11 January 2019

Our Reference: SYD18/00502/02 (A25424479)
Department Ref: SSD 9210

**MASTERPLAN FOR PROPOSED SAINTS PETER AND PAUL ASSYRIAN PRIMARY SCHOOL
IN KOSOVICH PLACE, CECIL PARK**

CLIENT / Project:
Saint Peter & Assyrian Primary School

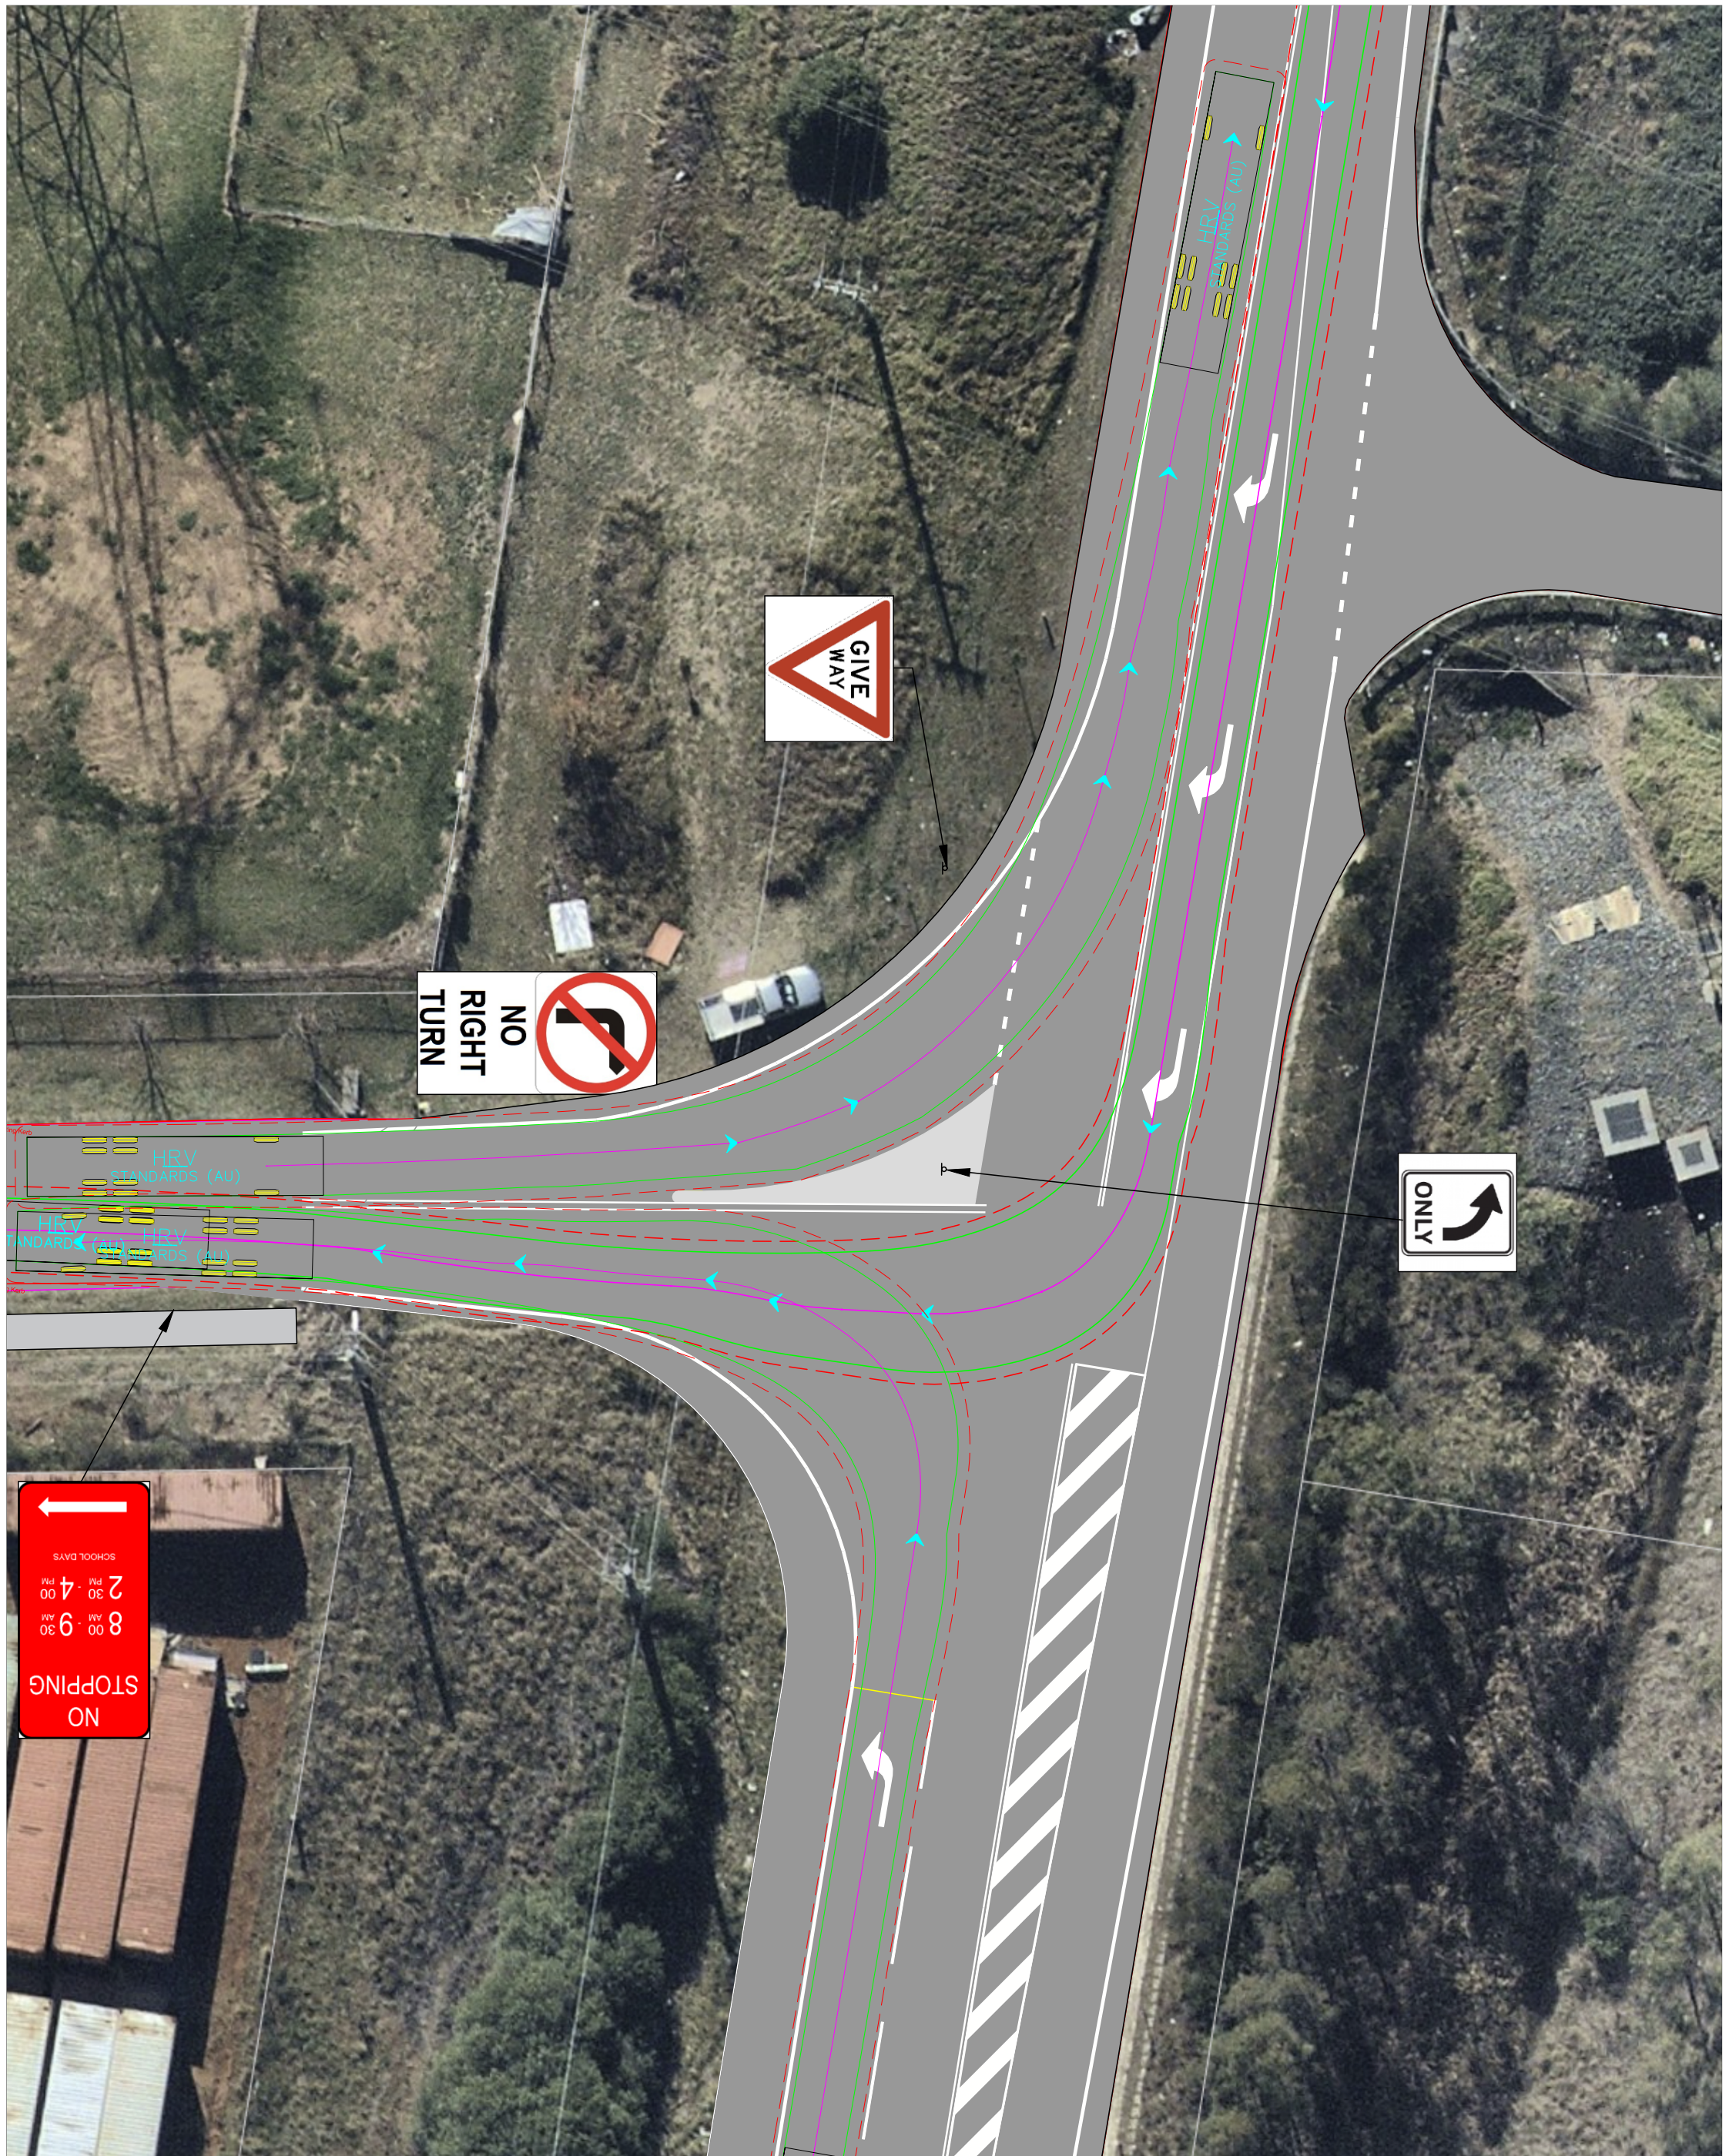
Considering Wallgrove Road is an 80 km/hr speed zone road and right turning traffic has to negotiate with heavy volume of through traffic Roads and Maritime does not support proposed right turn bay (CHR) treatment on Wallgrove Road at Kosovich Place intersection. This would be a potential safety hazard for right turn traffic as motorists have to wait for a safe gap which could frustrate the drivers due to the high through traffic volume. In addition, Roads and Maritime does not support proposed banning of right turn from Kosovich Place into Wallgrove Road as this would increase unnecessary pressure at the roundabout of Wallgrove Road and Villiers Road.

Based on the above and considering safety for the school children Roads and Maritime suggest a roundabout at the intersection of Kosovich Place and Wallgrove Road. It would improve the safety for turning traffic and also would reduce the approach speed at the subject intersection.
